Application number: 2026/90279	
What is the application for?:	Erection of two storey side and rear extensions
Address of the site or building:	17, Holyoake Avenue, Healey, Batley, WF17 7HB
Postcode:	WF17 7HB

Drawing Title:
PROPOSED ELEVATION

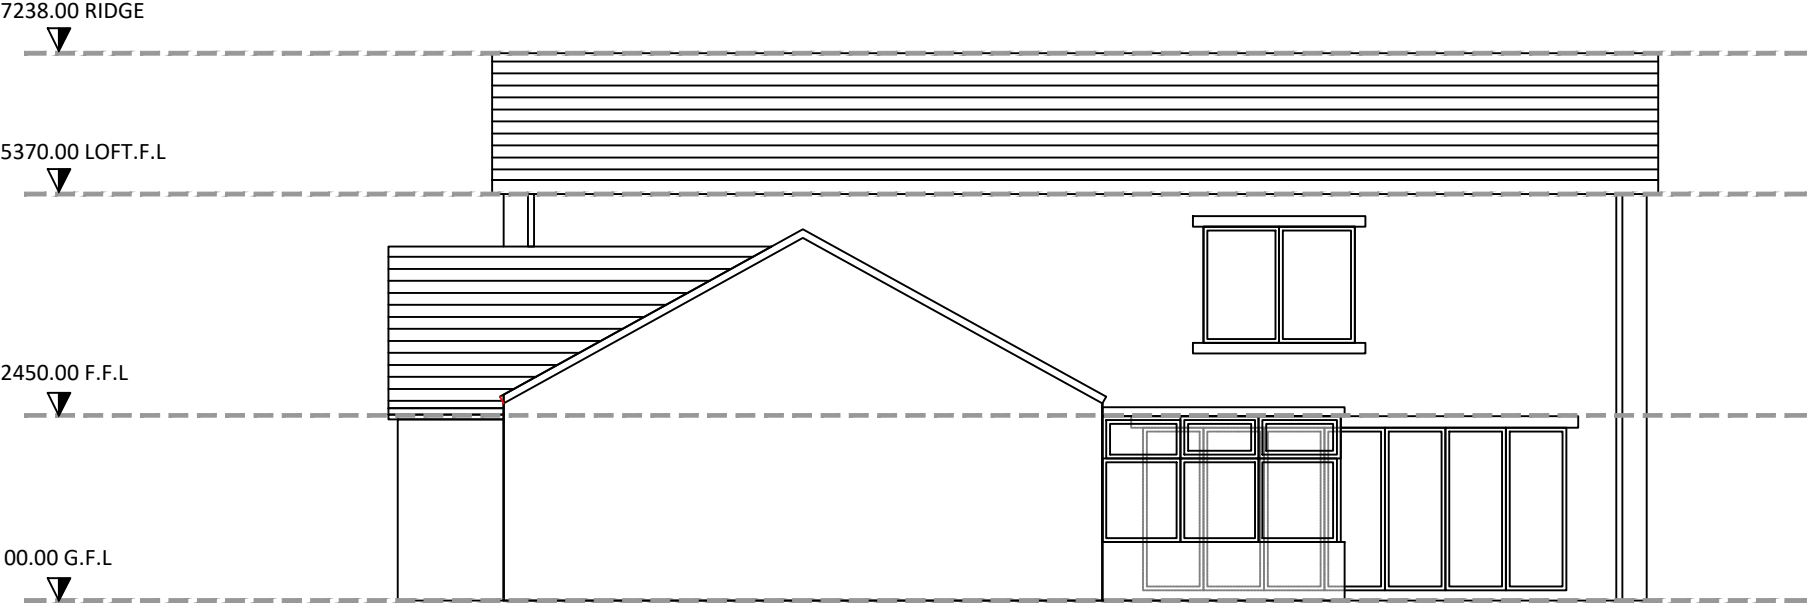
Type of comment: An objection	
Do you wish your comments to be published on the website anonymously?	Yes
The proposal would substantially increase the height, width and overall mass of the property. This would create an overbearing and enclosed feeling when viewed from and the large expanse of brickwork and roof structure would be visually dominant. Concerns regarding loss of light and overshadowing Privacy is a concern, the proposed elevations show additional upper-floor windows, and because of the close relationship between the properties, these could increase overlooking towards and potentially towards habitable rooms.
